# MDT-SF22035-R1-Plat.pdf Markup Summary

SF-22-035

STERLING RANCH EAST FILING NO. 1
JOB NO. 1183.30
NOVEMBER 9, 2022
SHEET 4 OF 10

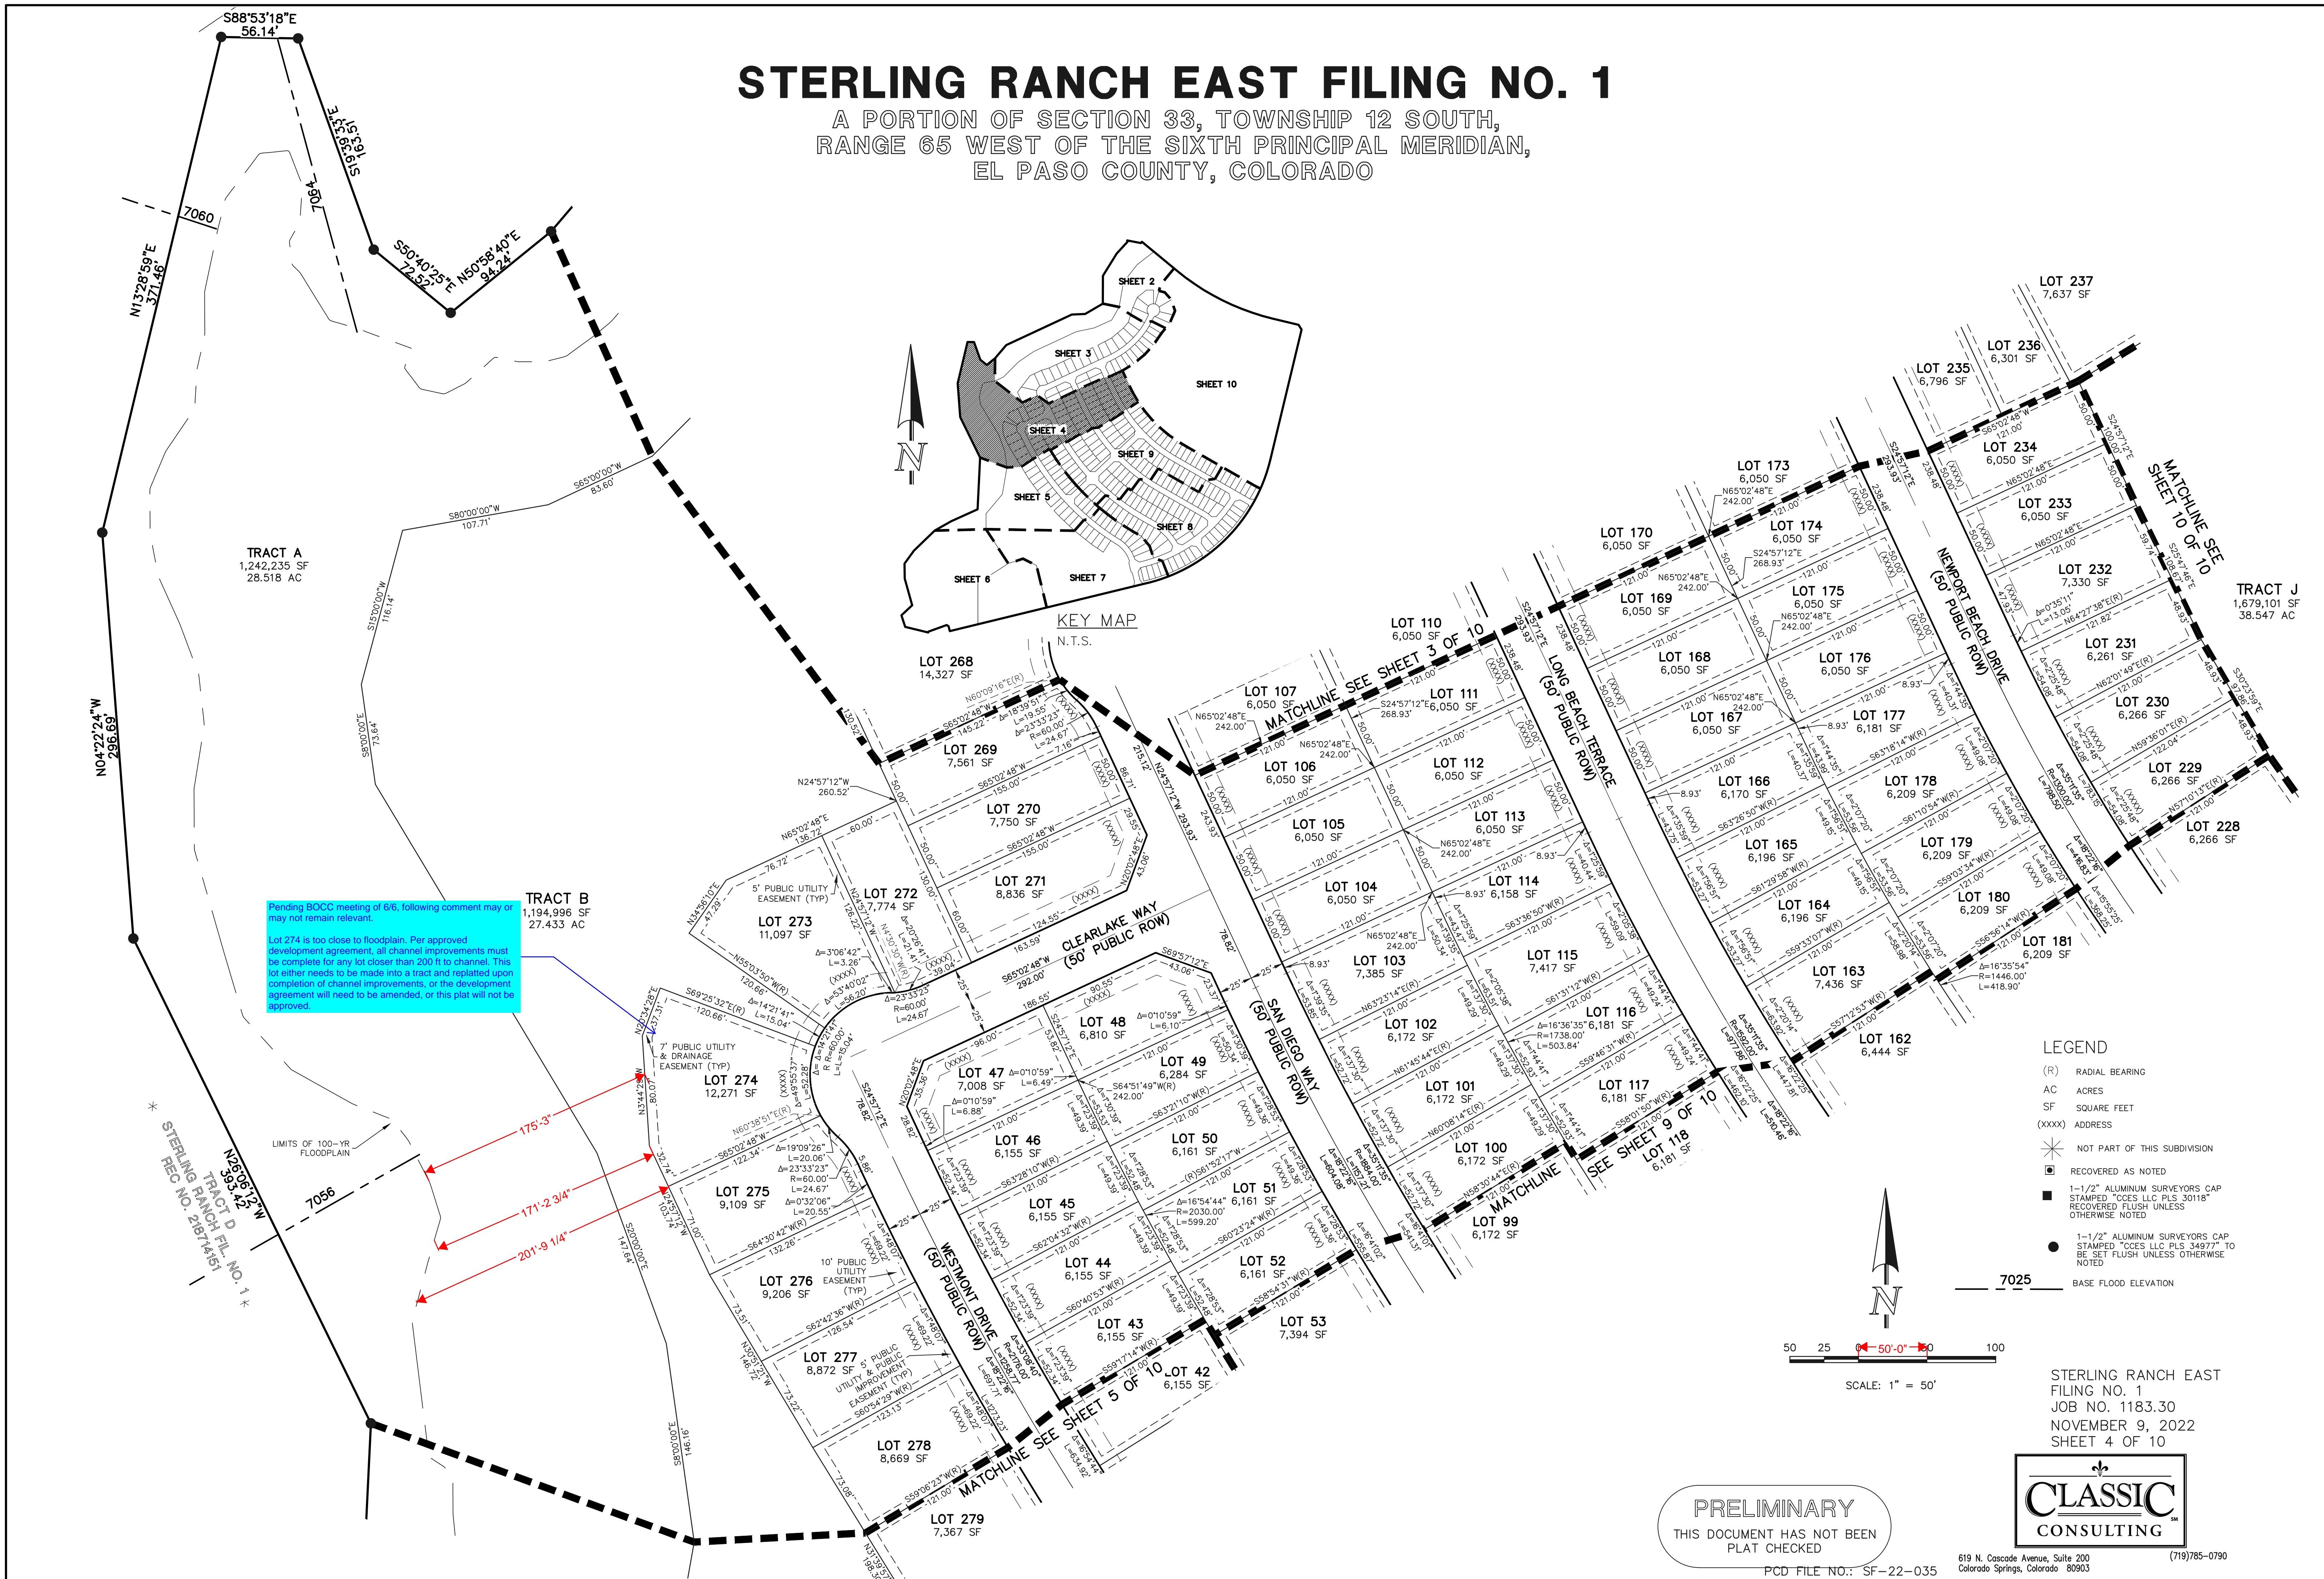
please include the school tract and land between this dev, and Briargate so its not a leftover parcel.

are there no trail connections?

Lots 274 and 275 are too close to floodplain (<200') per development agreement.

STERLING RANCH EAST FILING NO. 1
JOB NO. 1183.30
NOVEMBER 9, 2022
SHEET 8 OF 10

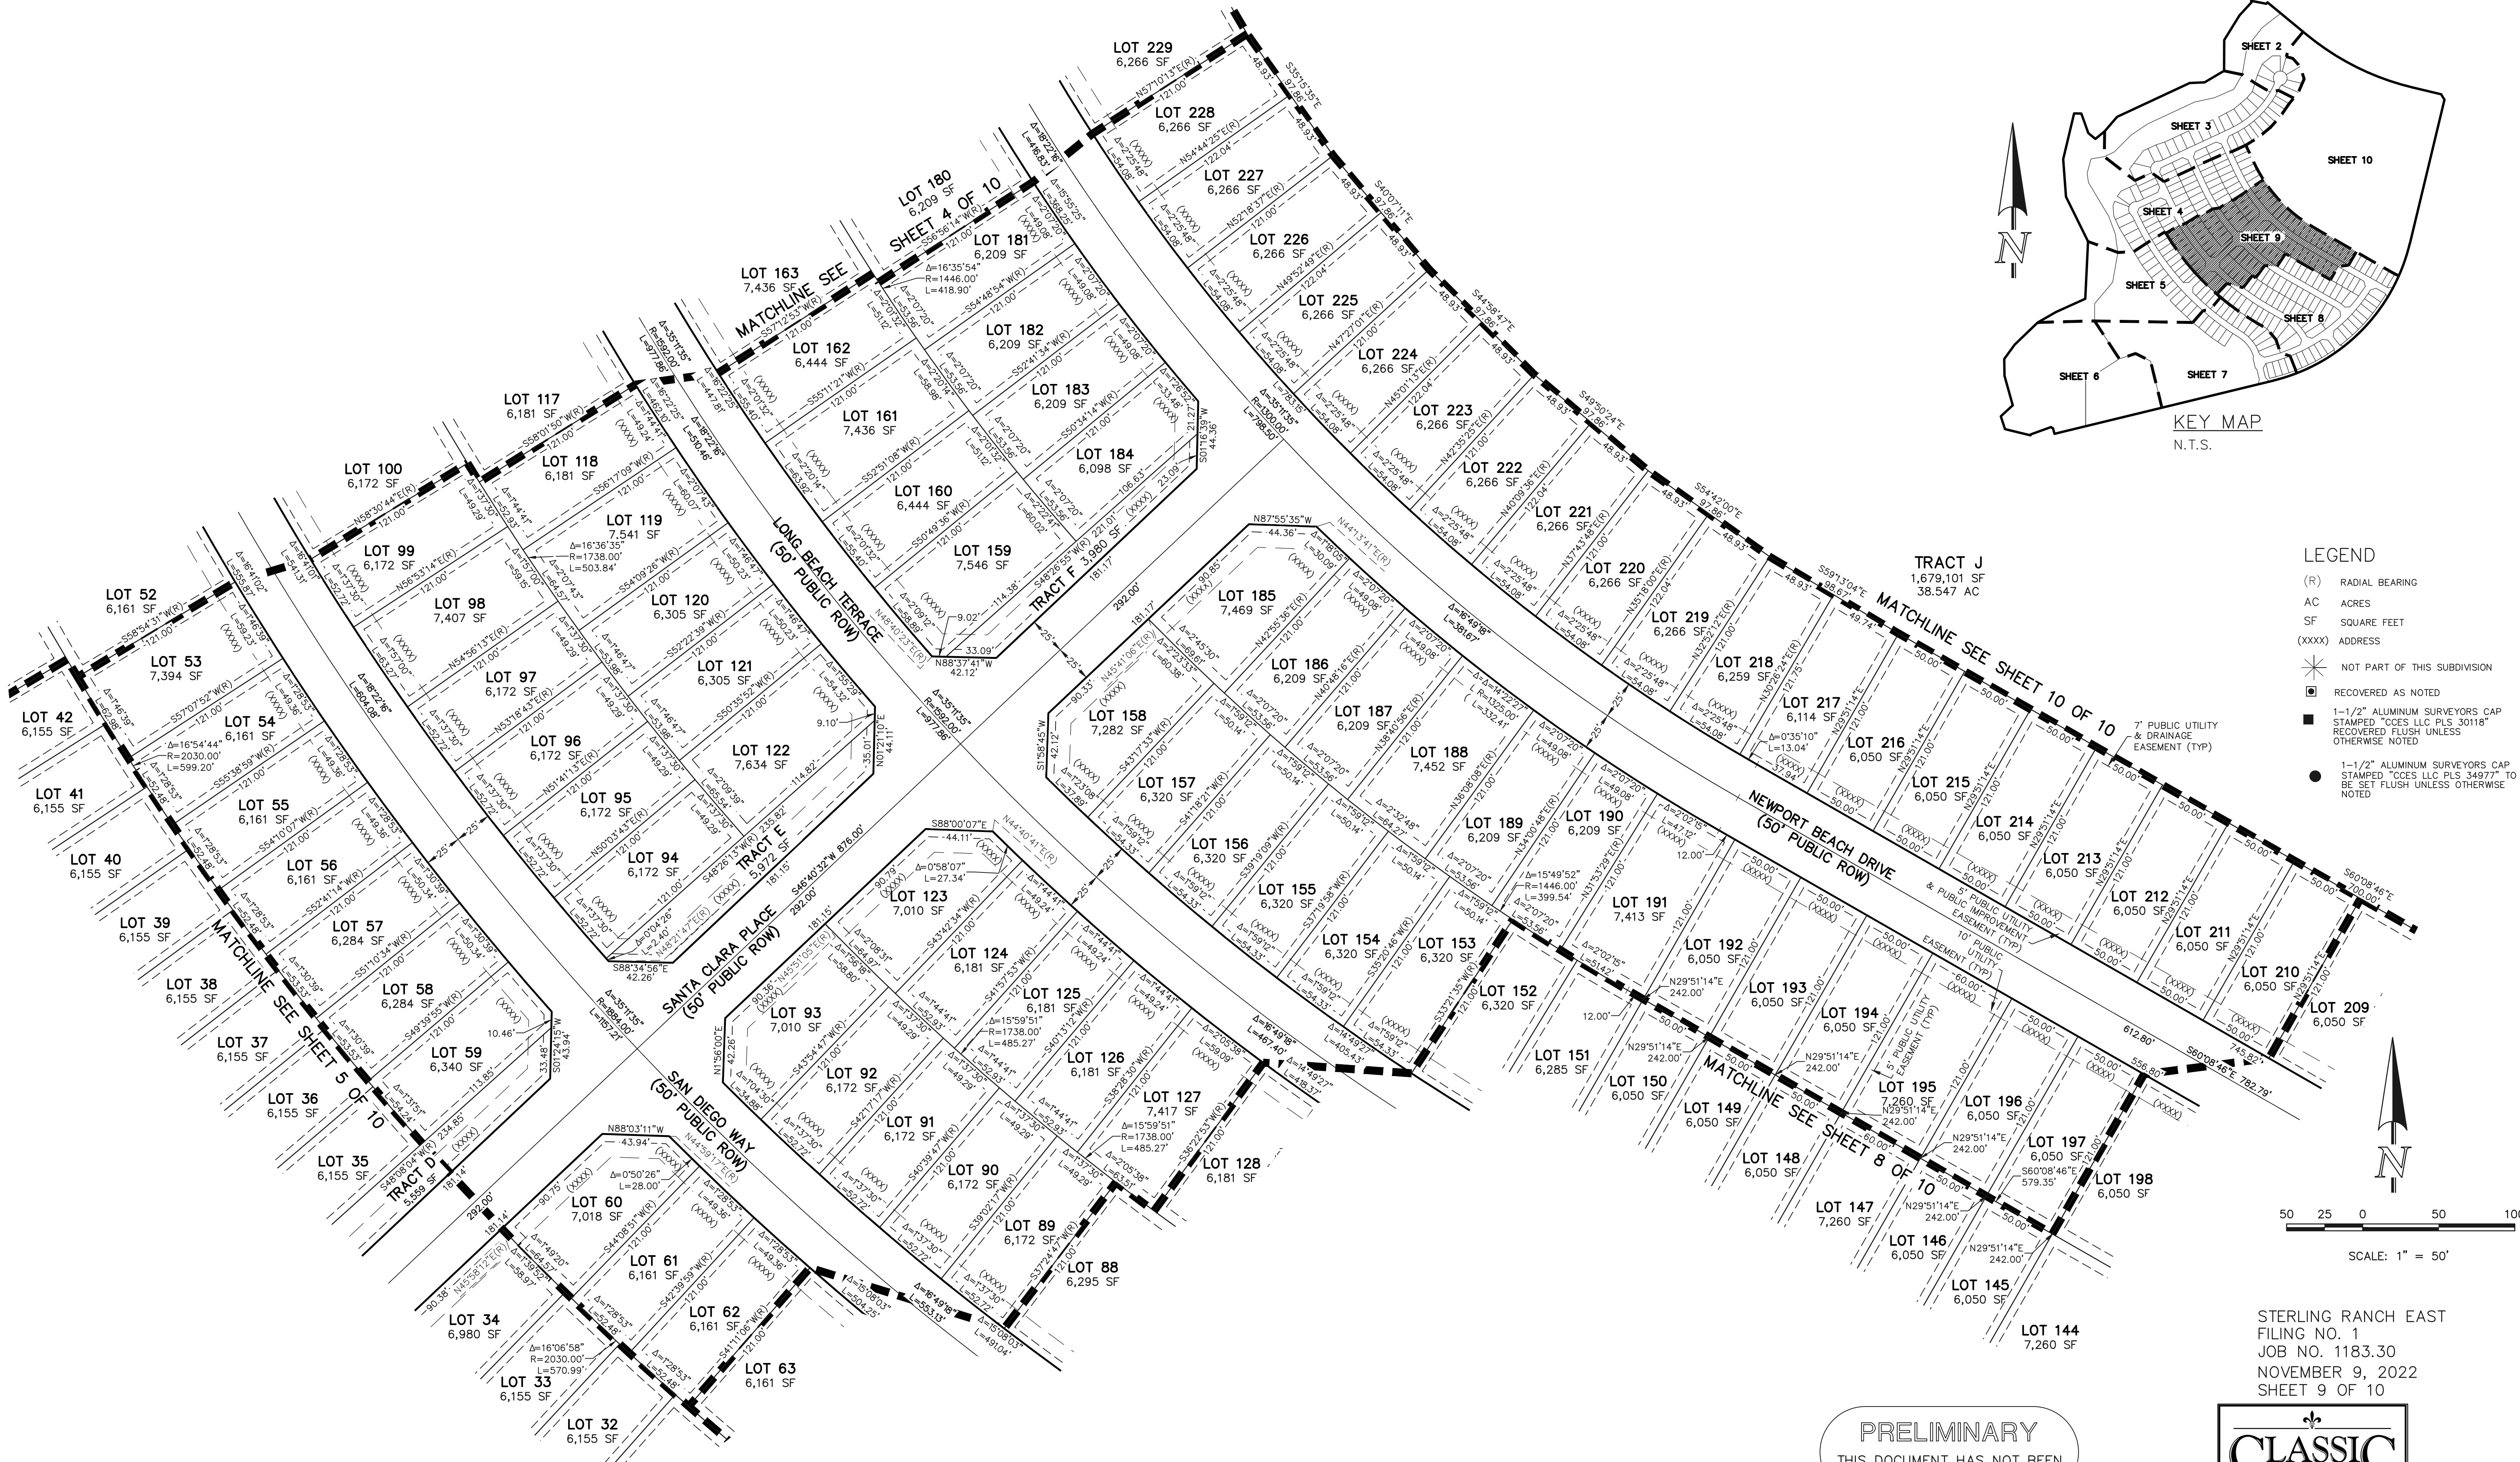
is this to be constructed with this plat for access?  
Iclide row.

delete "future" if Homestead North 1 will be  
recorded prior to this plat

80' ROW Non-residential Collector

STERLING RANCH EAST
FILING NO. 1
JOB NO. 1183.30
NOVEMBER 9, 2022
SHEET 2 OF 10

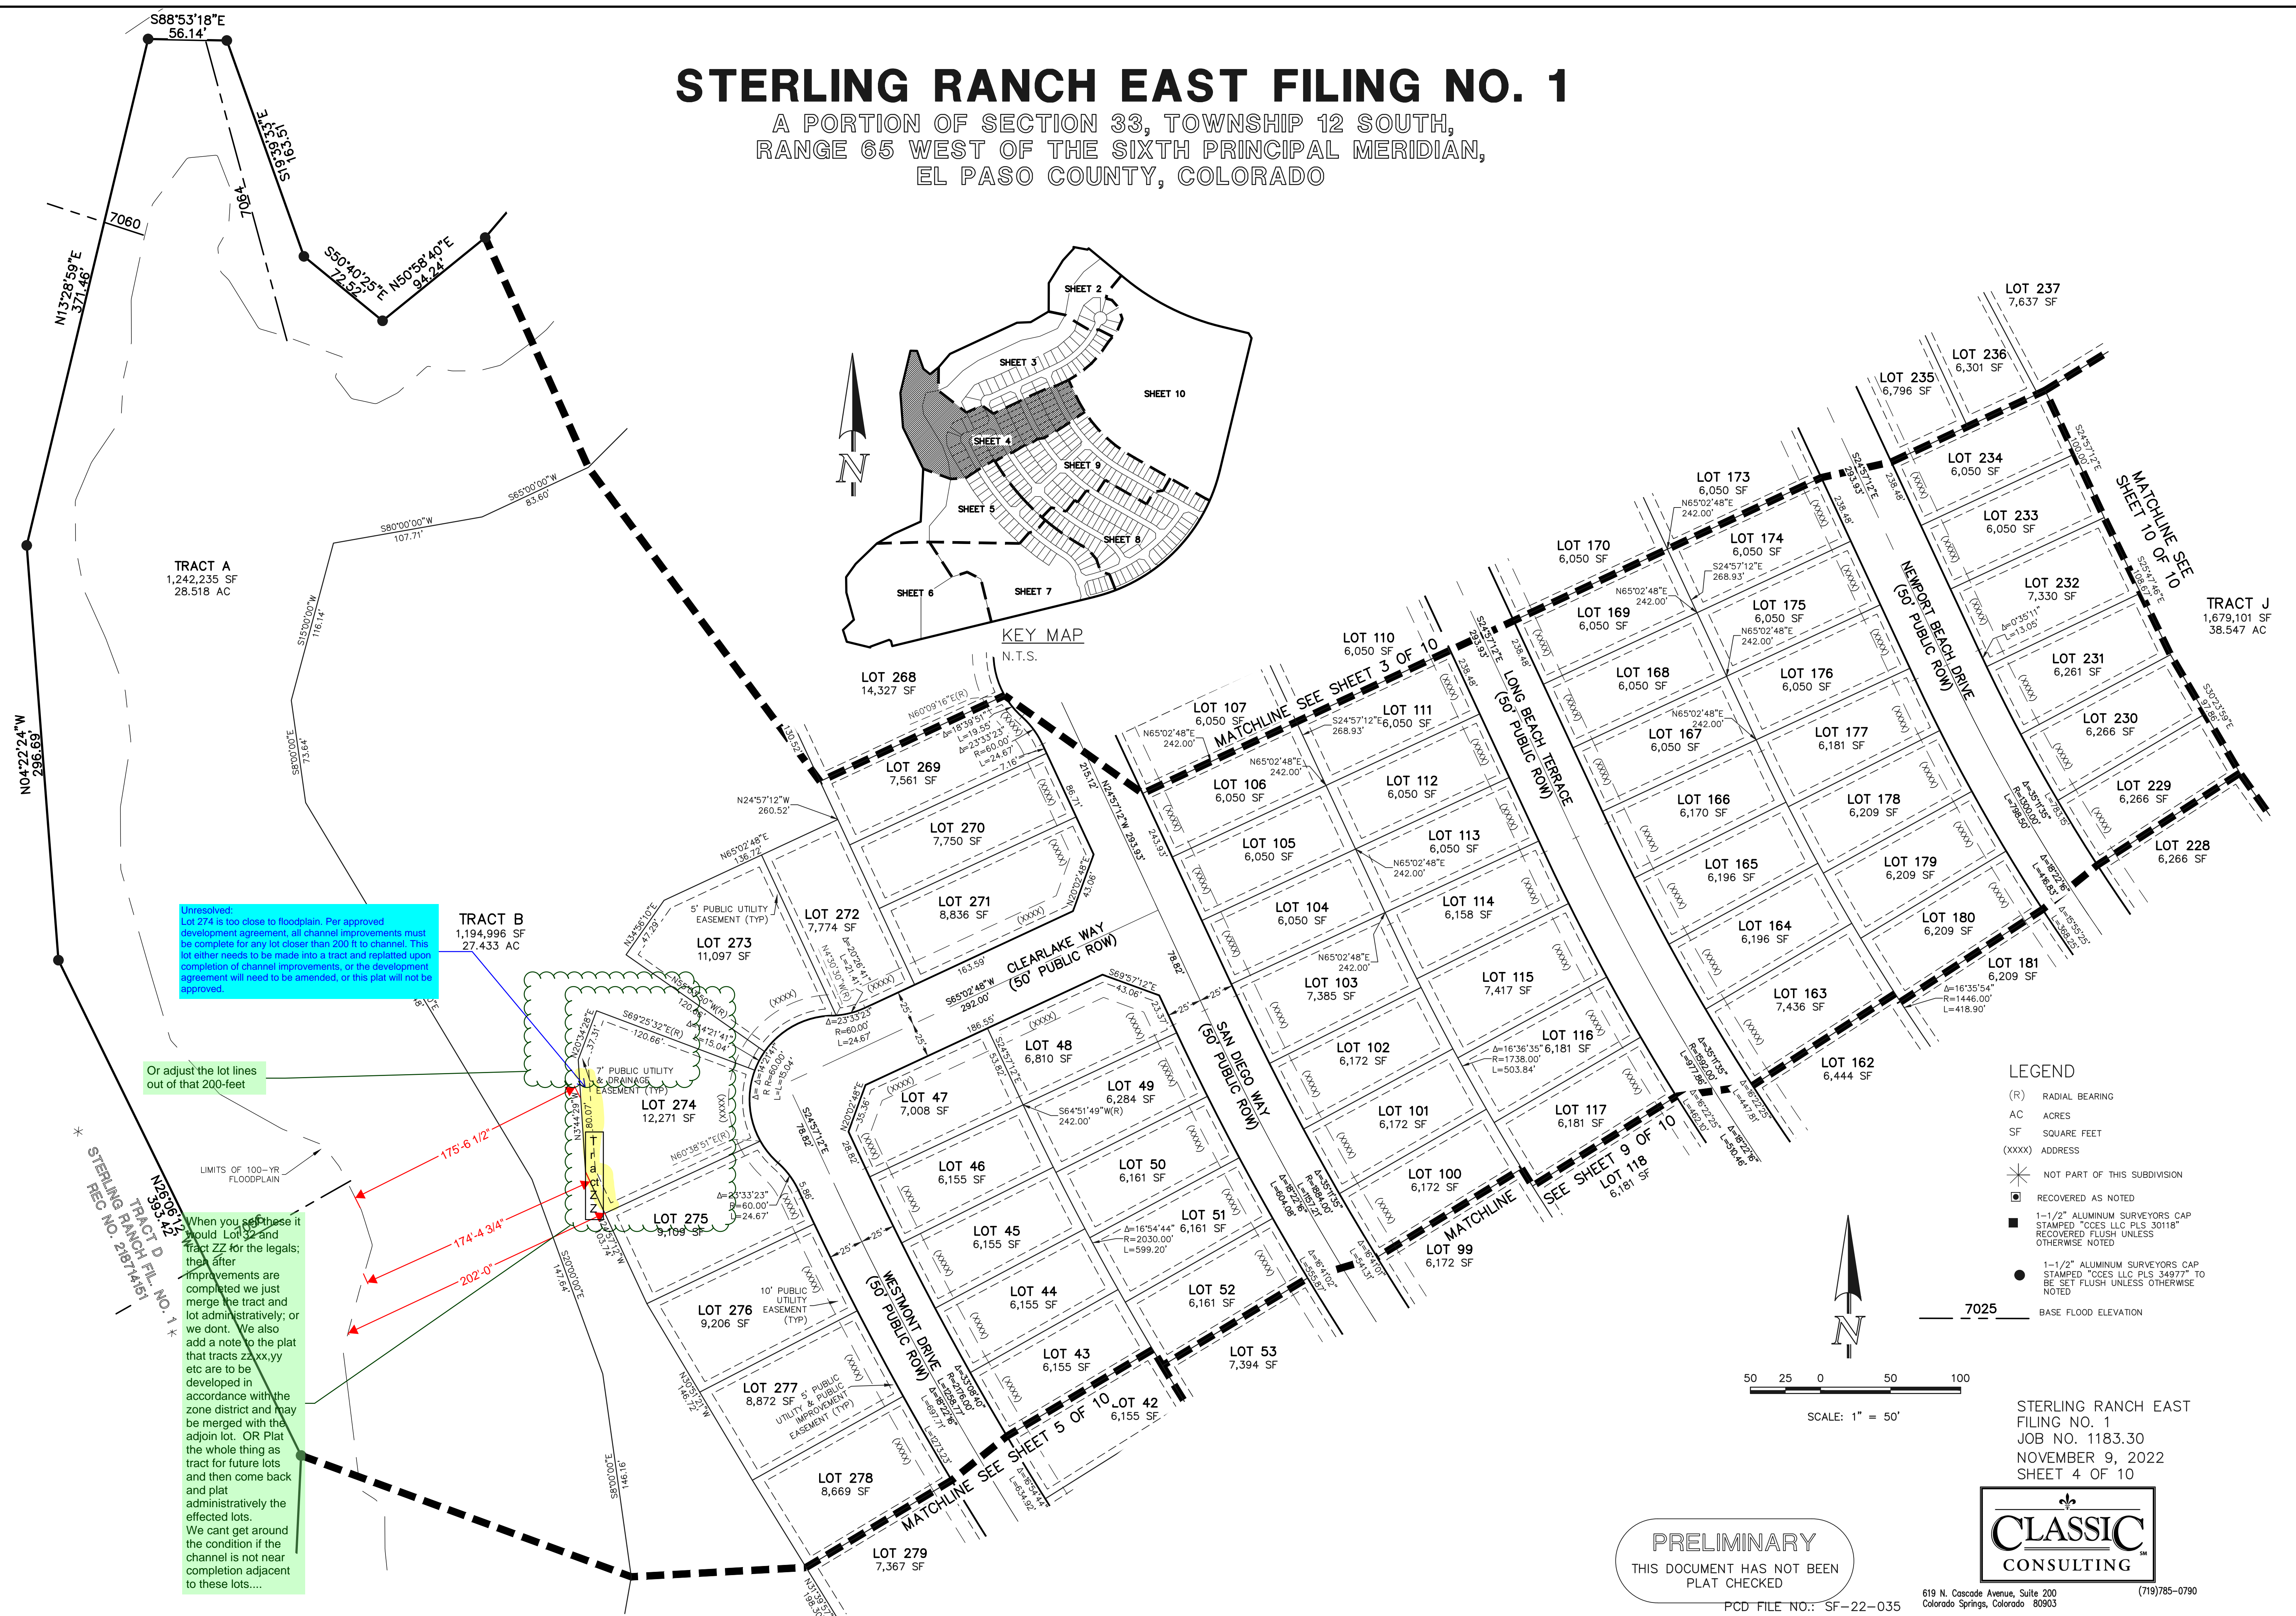
Bearings/Distances shown from POC & POB do not appear to match information given legal description on cover sheet. Please update between two locations.

Include roadway classification & ROW width

delete "future" if Homestead North 1 will be recorded prior to this plat
